Revision E - Section 75W Amendments.
1 Four spaces have been converted to two disabled spaces to accommodate increase in total adaptable apartments numbers (additional 2, from 59 to 61)

Site 3
Sydney Olympic Park
Plan
Basement 001

Revision E - Section 75W Amendments.

Drawing No: DA05.02[E] [Revision]

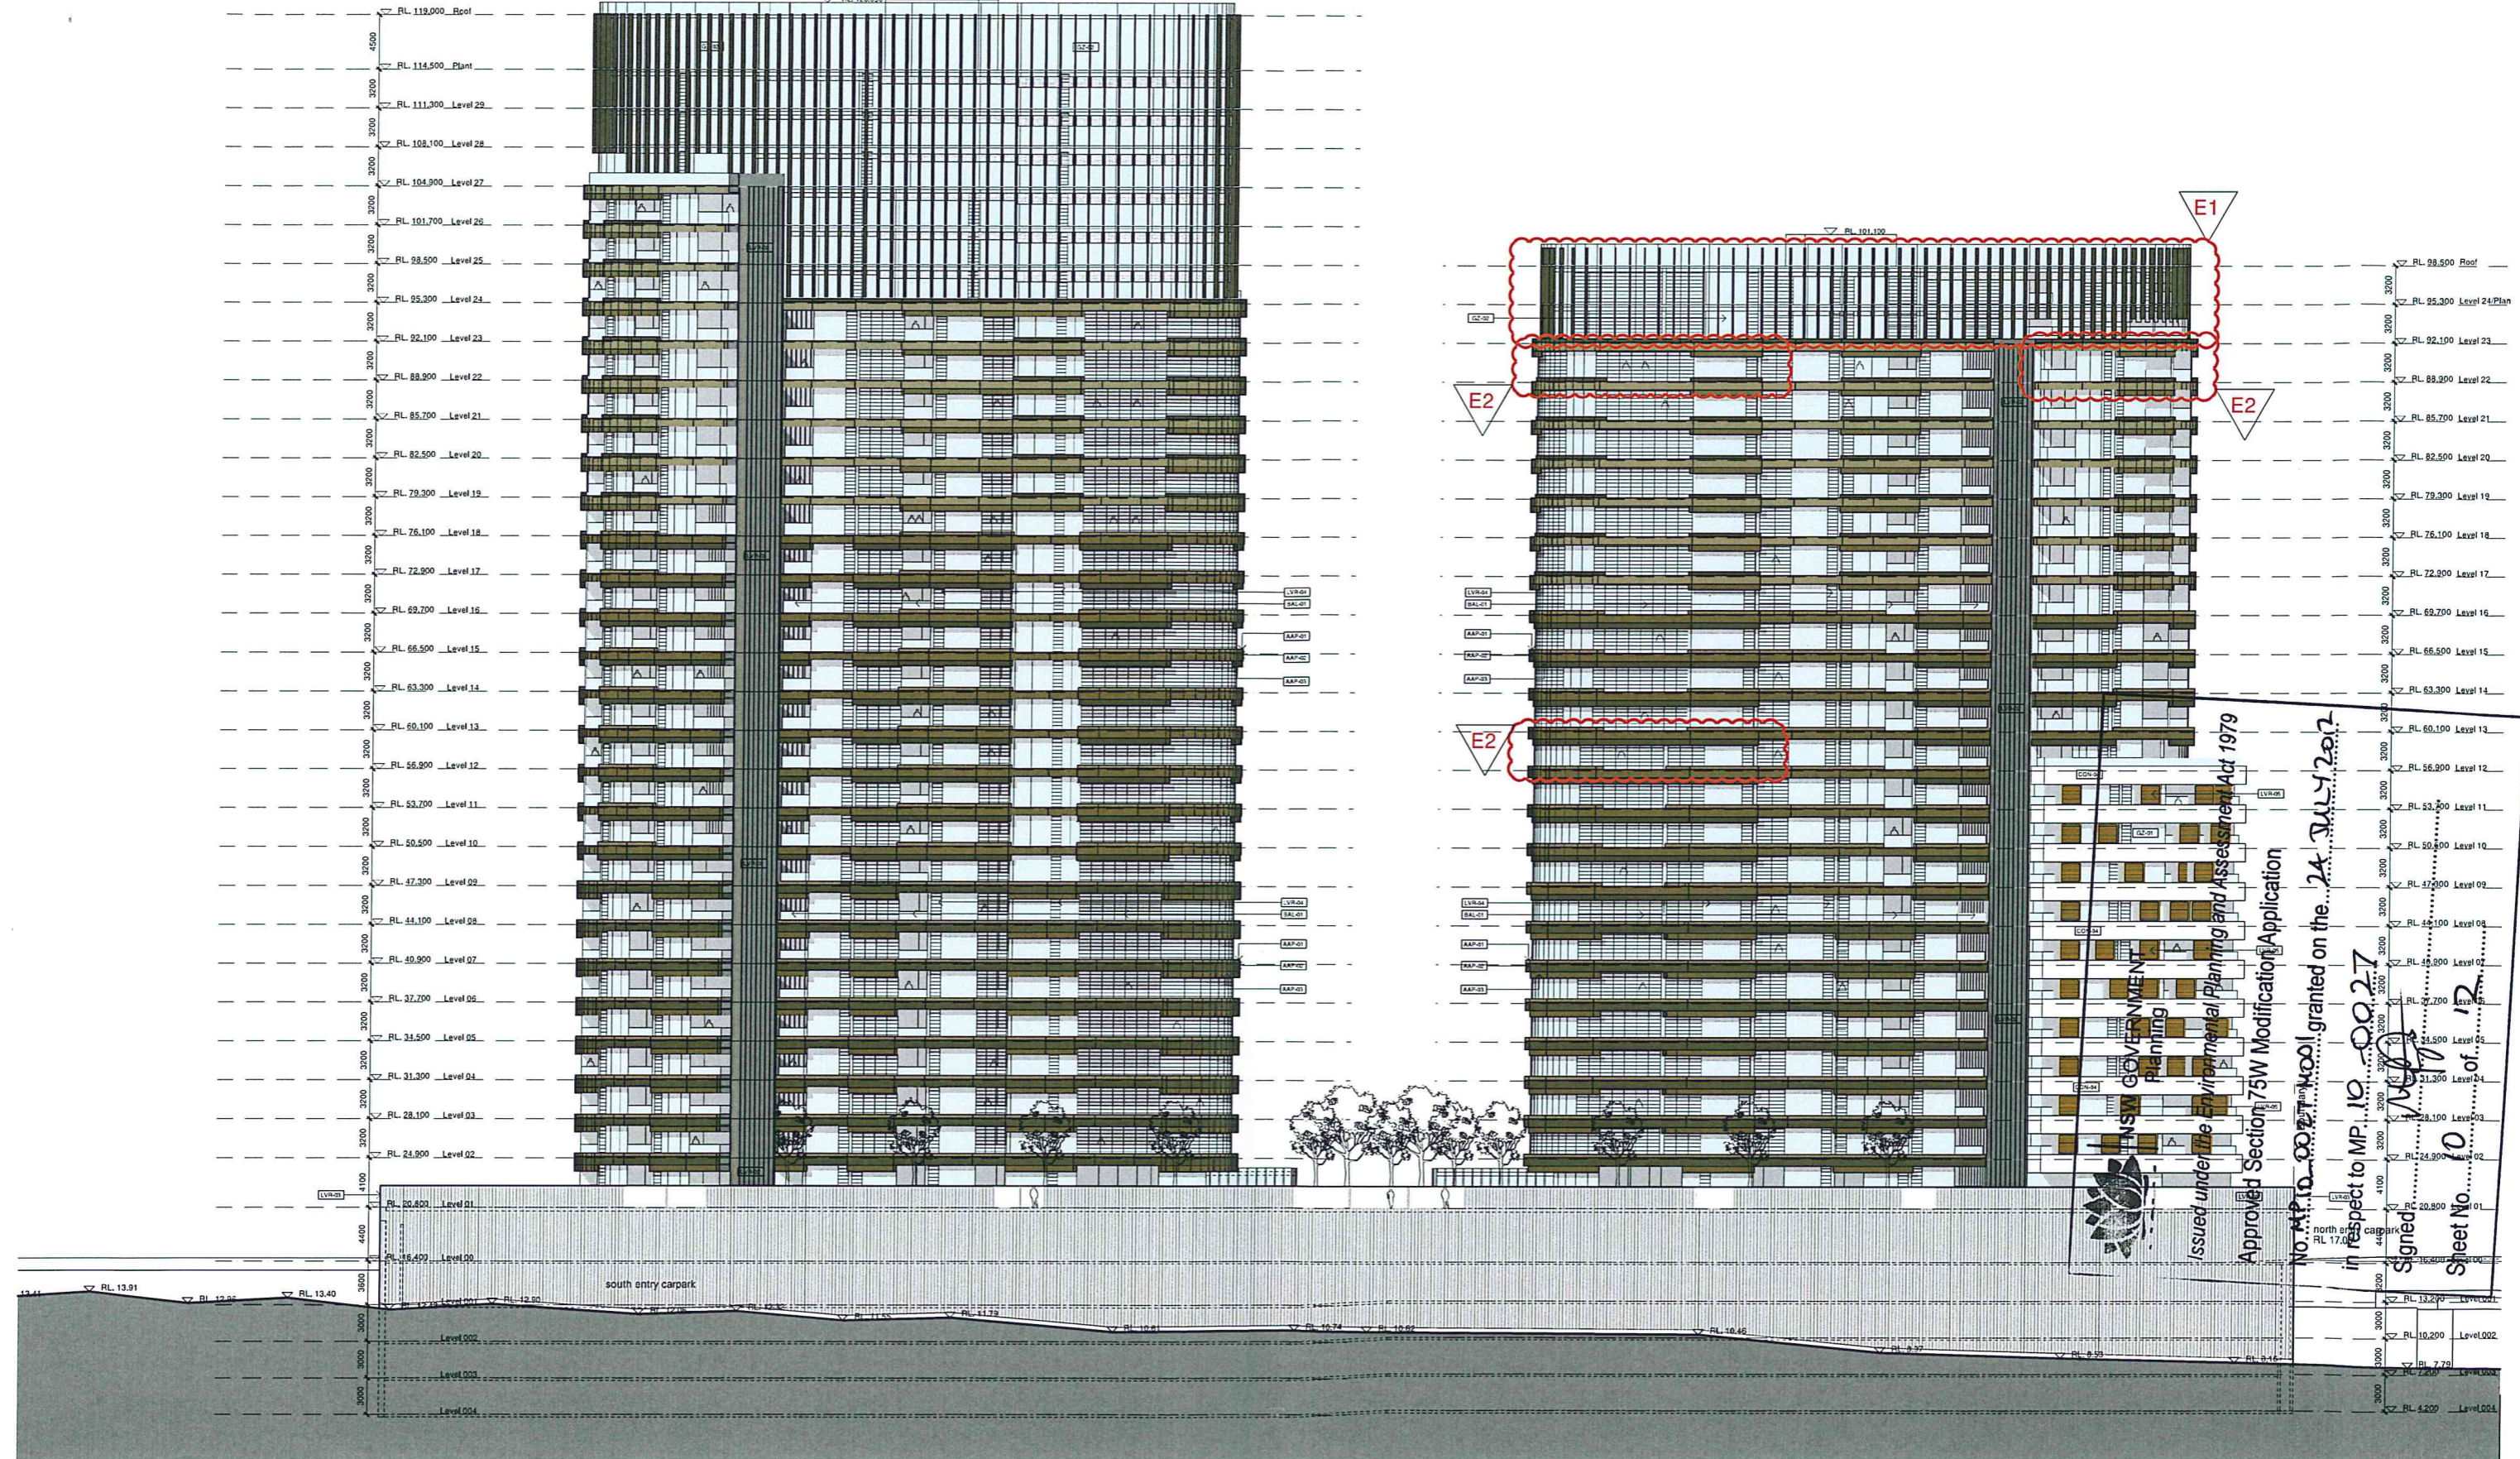
Revision E - Section 75W Amendments.
1. Loft apartments modified to single storey apartments on Level 23 & 24. Elevation amended to match current plans.
2. Elevation amended to match current plans.

DA06.01[E]

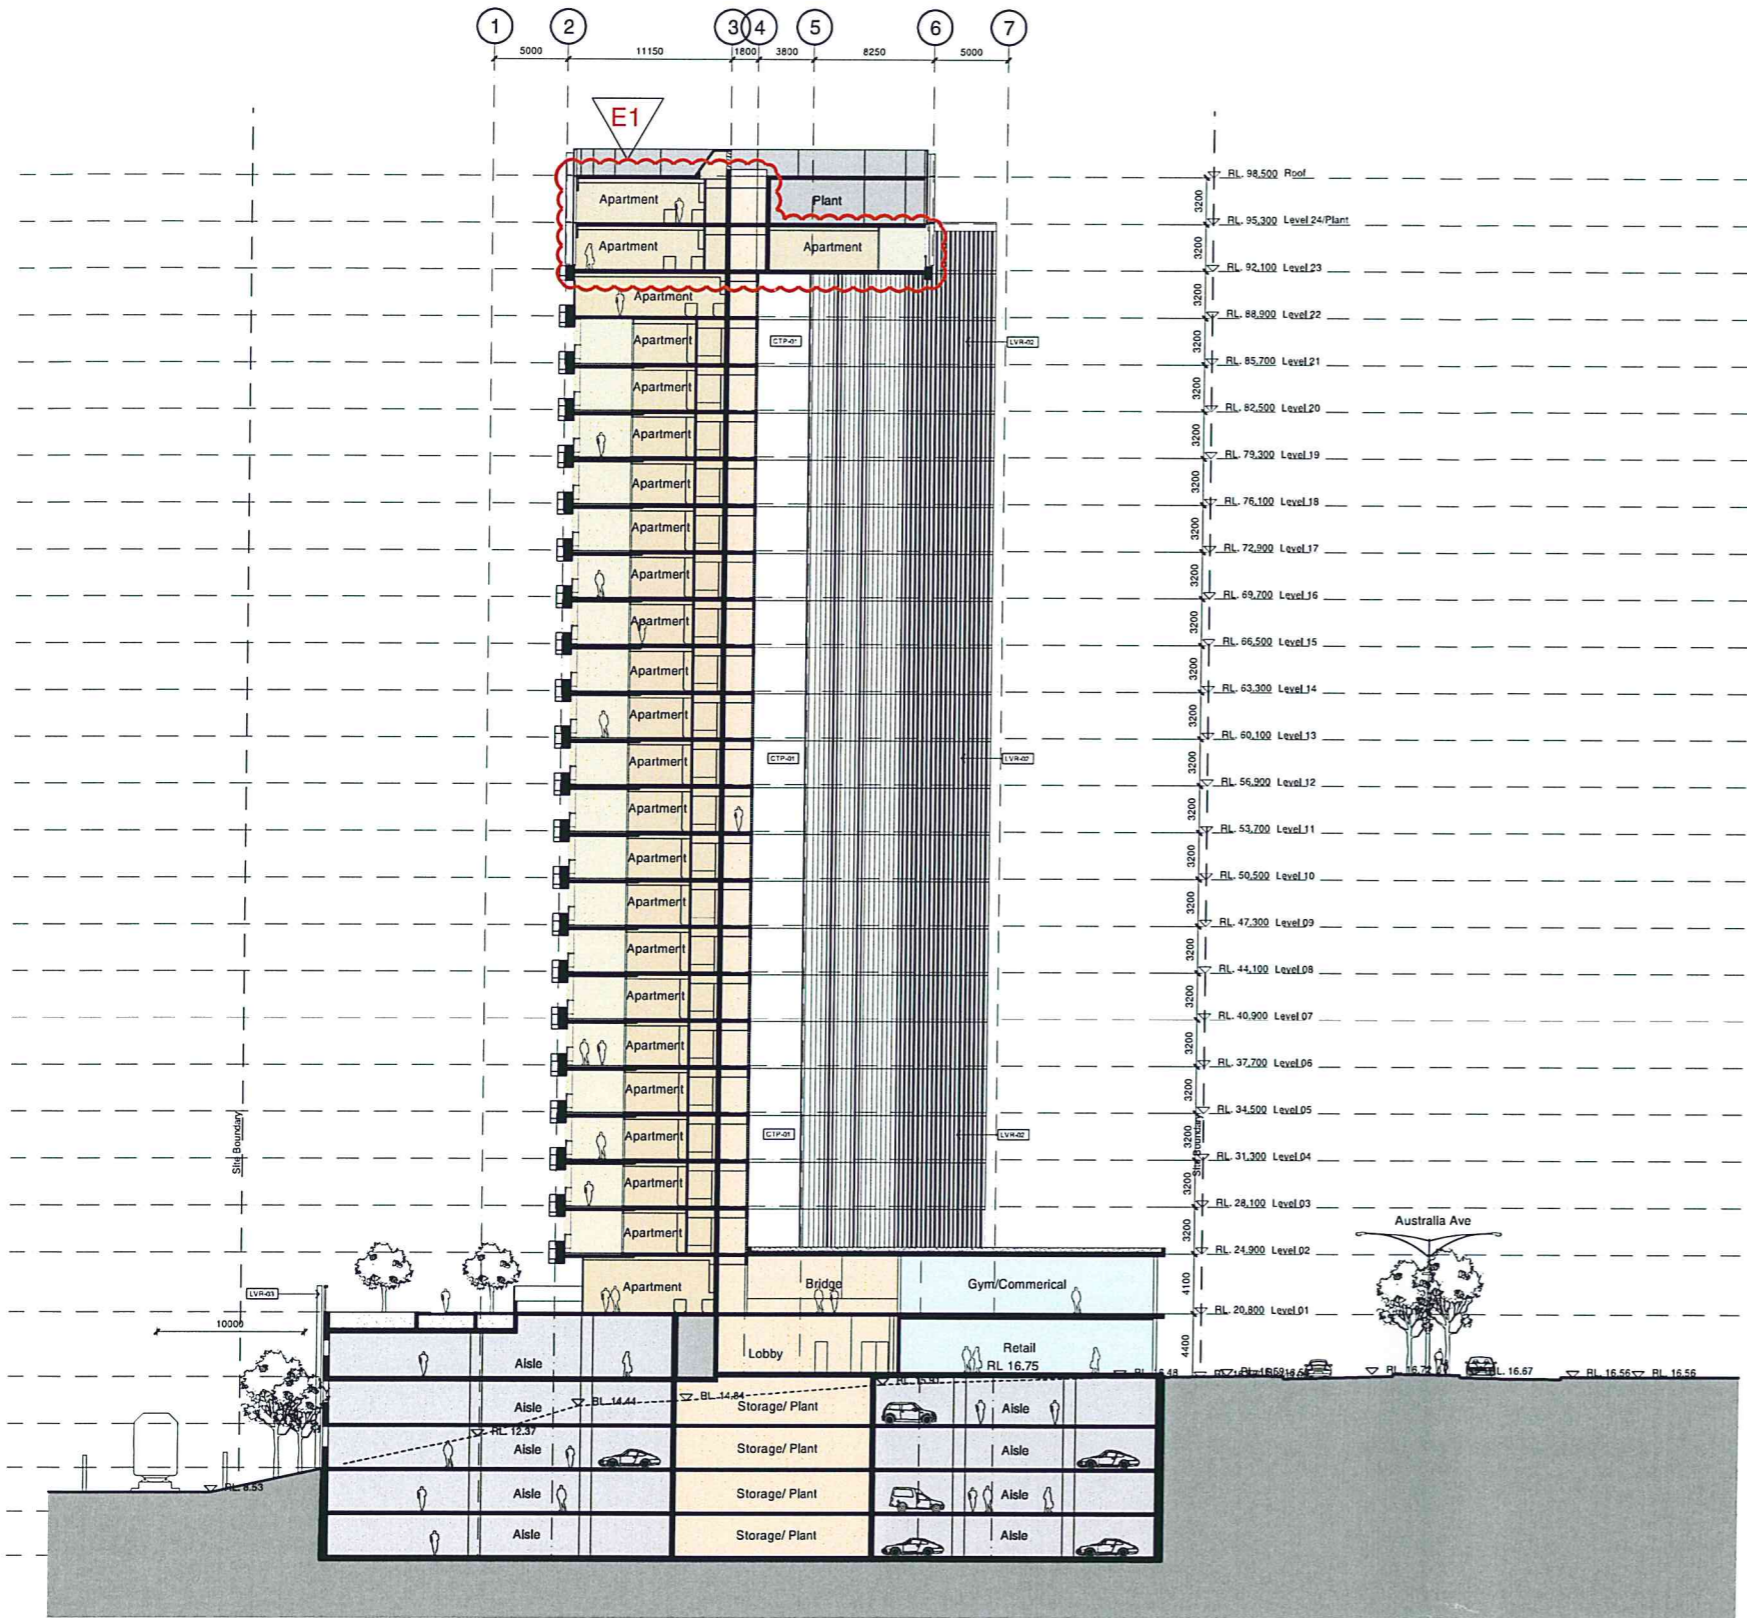
1. Loft apartments modified to single storey apartments on Level 23 & 24. Lift access has been extended to serve Level 24 apartments.
